Subject: RE: Proposed Development at East St/Fitzalan Rd, Littlehampton: Planning Ref. LU/127/17/DOC

Proposed Development at East St/Fitzalan Rd, Littlehampton
Planning Ref. LU/127/17/DOC
Planning Application Ref. LU/173/16/PL

We have recently received a copy of your e-mail dated 16 May 2017, as issued to Anita Gardner – Principal Planner, Arun District Council (included below) and note that you have raised some issues relating to our Geotechnical Assessment Report No. CCL02814.CD70, dated May 2017. We clarify these matters below.

SOAKAWAY CONSTRAINTS PLAN

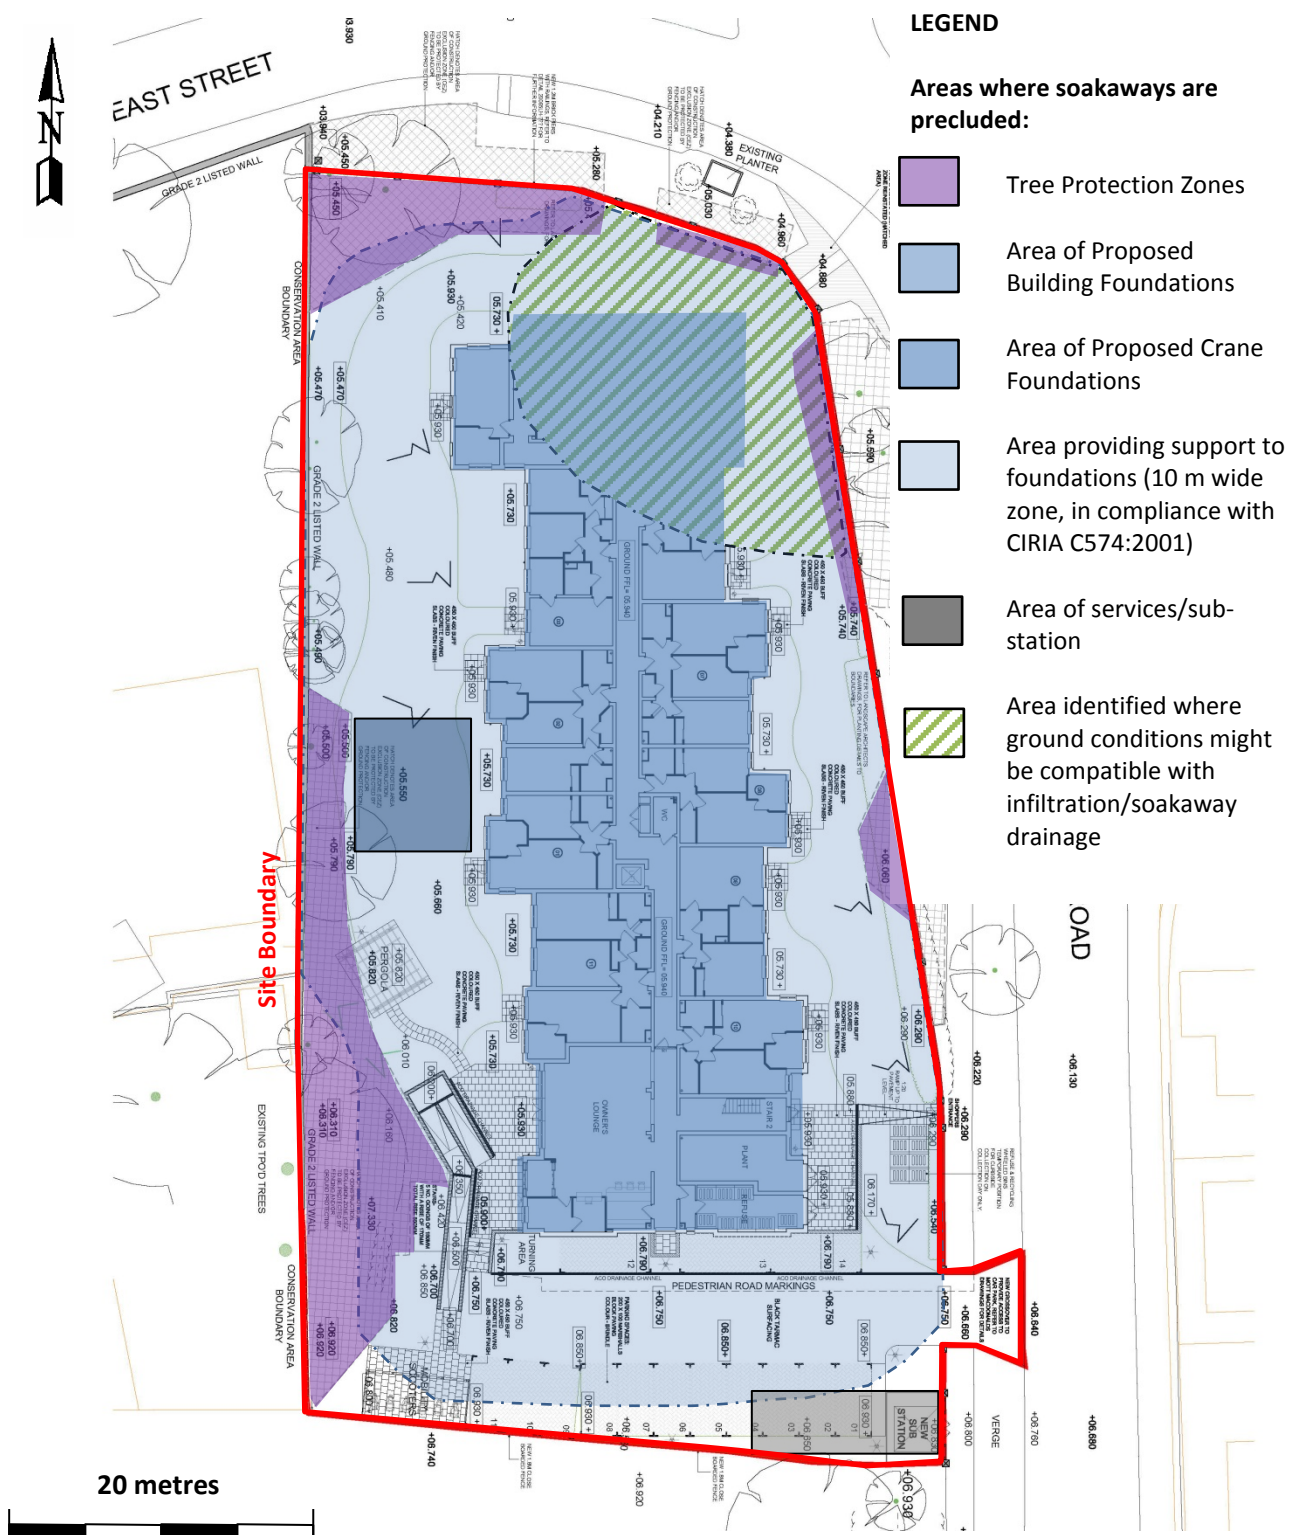
1. Can you advise the depth to the chalk to the west of the proposed new building. Both TP2 and TP3 did not achieve sufficient depth, to identify the depth of the chalk. If chalk is present at an acceptable depth then this will provide an opportunity for further percolation testing. The tests will need to sufficiently penetrate the chalk layer to make the best of any infiltration potential.

2. It is noted that TP1 and TP4 both penetrated the chalk, but are located beneath the proposed building. TP1, in which the test was carried out, only penetrated 200mm into the chalk. Despite this a reasonable infiltration rate was achieved (be it outside the winter period). TP4 penetrated 400mm into the chalk but no testing was carried out. Further trial holes/percolation testing can be carried out in areas that soakaways could be installed (ensuring 5m from buildings, outside of root protection areas, etc) ie. to the east and south of the new building.

Below the superficial deposits, highly weathered chalk strata are present. The depth to the chalk strata varies widely across the site, from 1.8 m to depths in excess of 5 m. Such variations occur over short distances, and it is evident that chalk is present at shallow depth only in very restricted areas (which are located below the proposed building).

It is noted that Grade Dc chalk has been observed at (only) 2 isolated locations within the site, and which included the infiltration test in trial pit TP1, where an infiltration rate of 3×10^{-6} m/s is recorded. Unfortunately, both of these locations are below the area of the proposed building, such that soakaway drainage is precluded at these positions.

Even if the development were to be reconfigured, it is noted that the areas of the site are very small where more permeable Grade Dc chalk has been identified, such that it is impracticable to provide the required size of soakaway drainage systems within such strata.
